Re: Planning Application 2022/62/93270/E
Proposed new build at 4 Caledonian Road, Dewsbury, WF12 9NT

We wish to lodge our objection to the development of a new detached house at the above address, as the design does not comply with both Local and National Planning Policies, outlined as follows.

Proposed First Floor Plan - 1:100

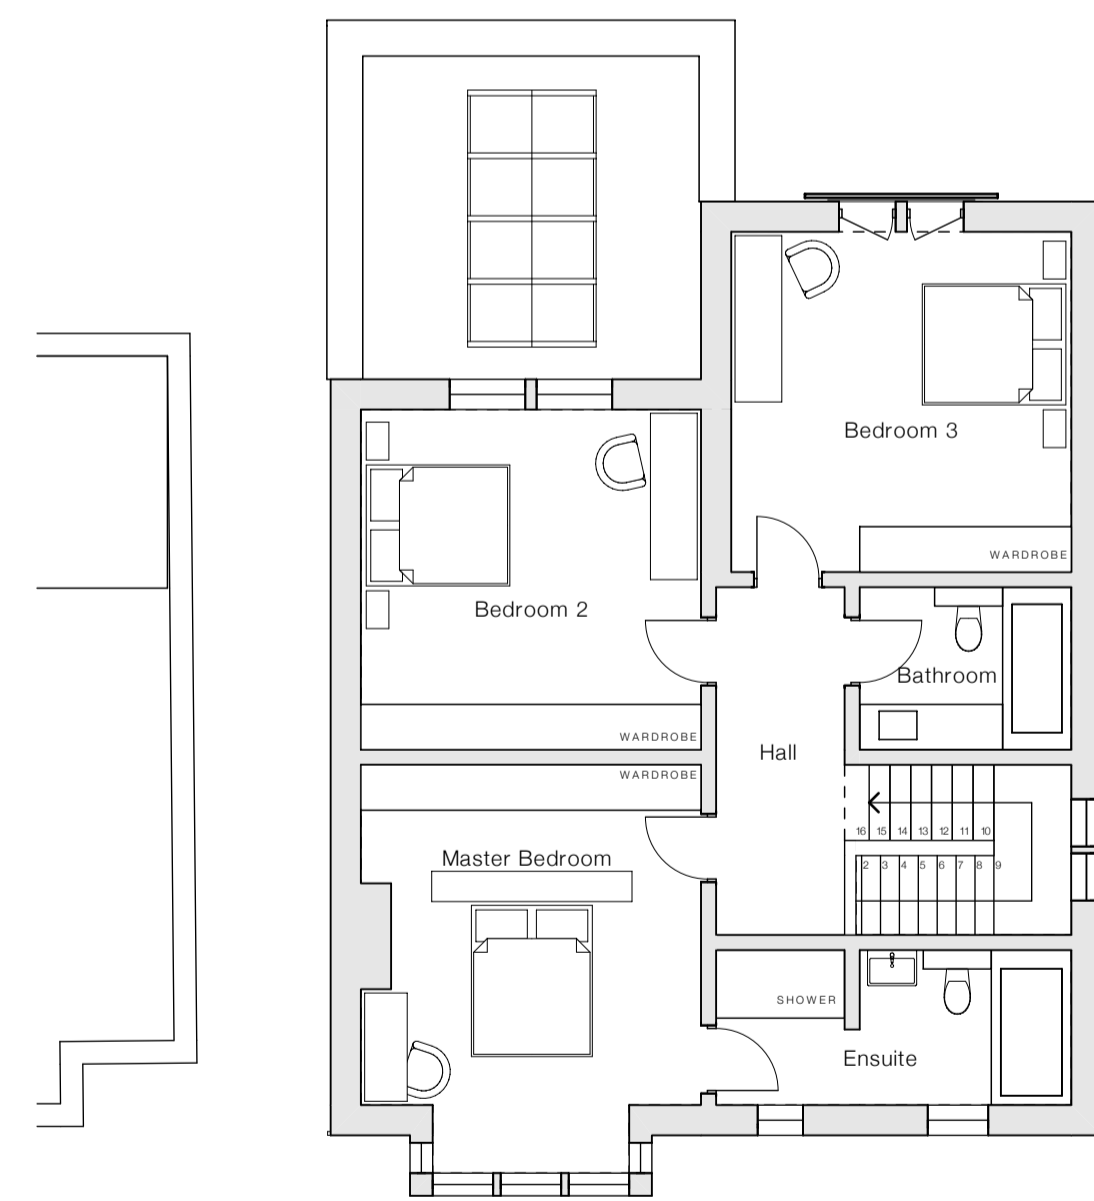
5. The bedroom No.3 has a wide window with a Juliet Balcony which will allow intrusion of the privacy on our rear garden. The existing dwelling view is blocked by the position of the rear garage building and the extent of the proposed dwelling to the rear allows a greater view of our garden. The design is contrary to:

Proposed Site Plan - 1:100

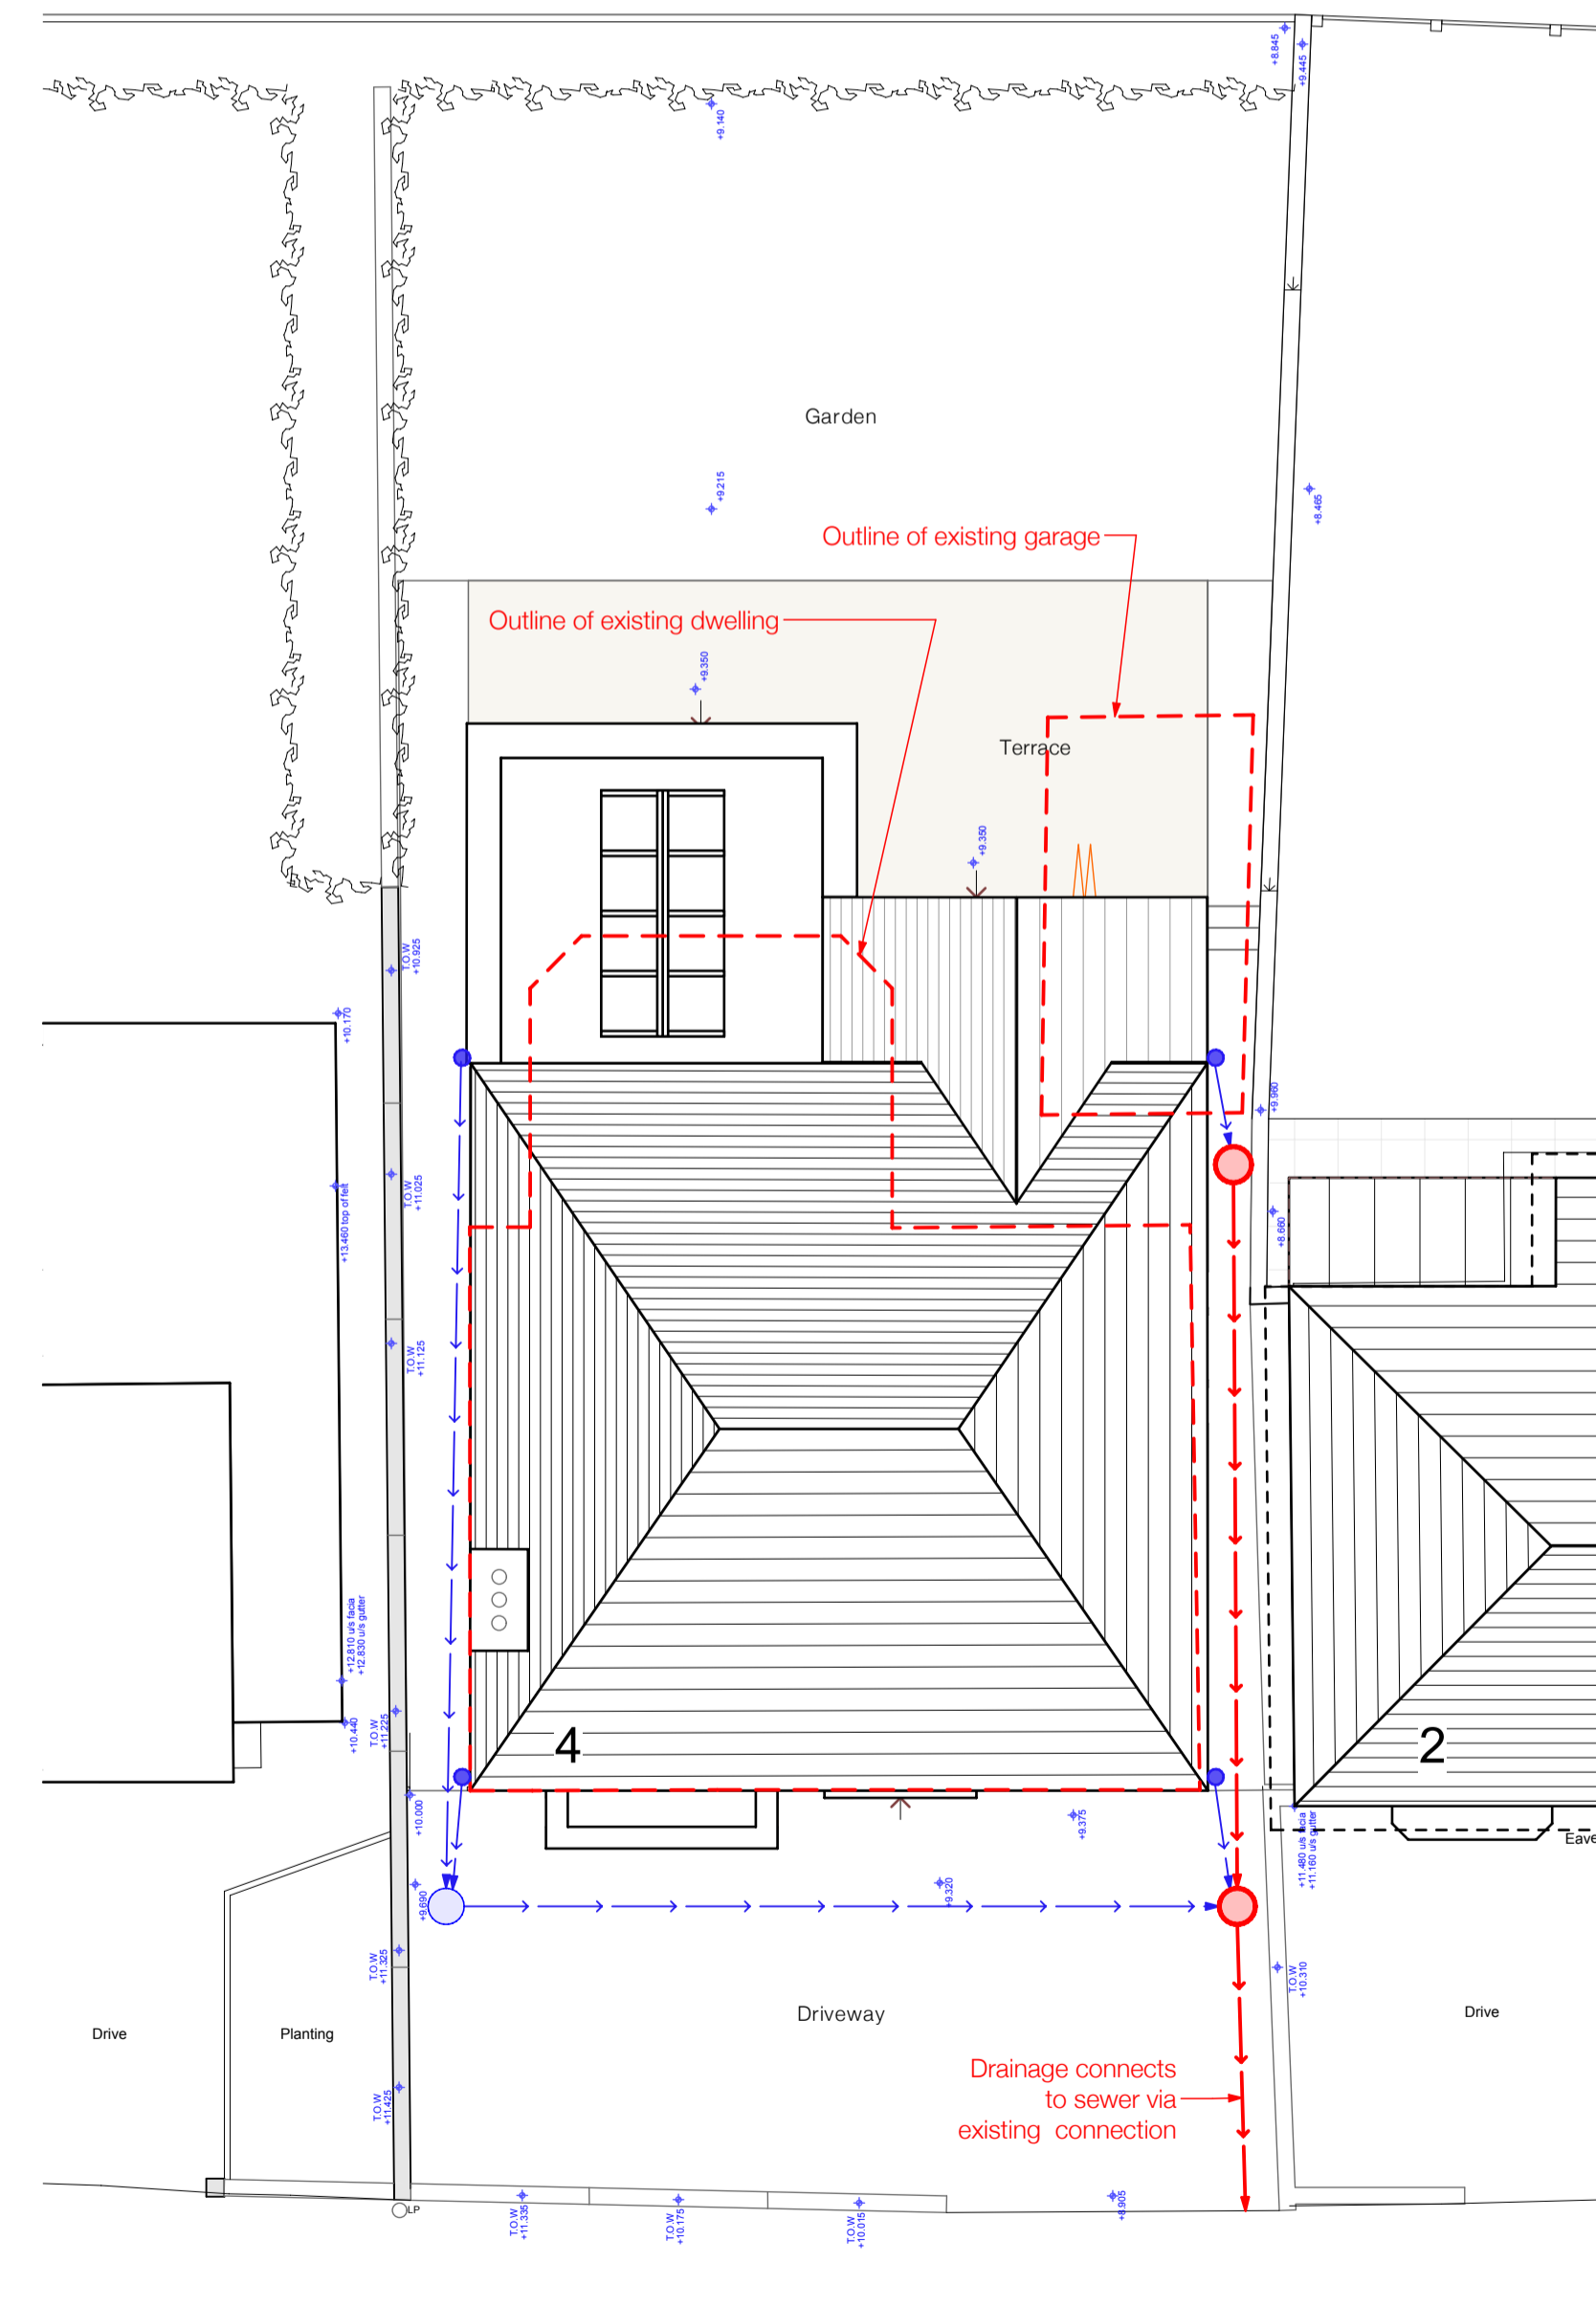
1. The Location Plan delineates a smaller house as currently exists.

2. The proposed design fails in complying with this part of the LP24 of the relevant Local Plan: The proposed new house extends a further 6 m beyond original alignment to rear, causing shadowing on our garden and loss of light, for most parts of the day, contrary to guidelines in House Extensions and Alterations.

The proposal seems to move the new dwelling nearer our gable. It is not possible to measure this accurately, though the plans are drawn to scale as stated, no relevant dimensions are highlighted. It appears that the proposal also falls down under the requirements of:
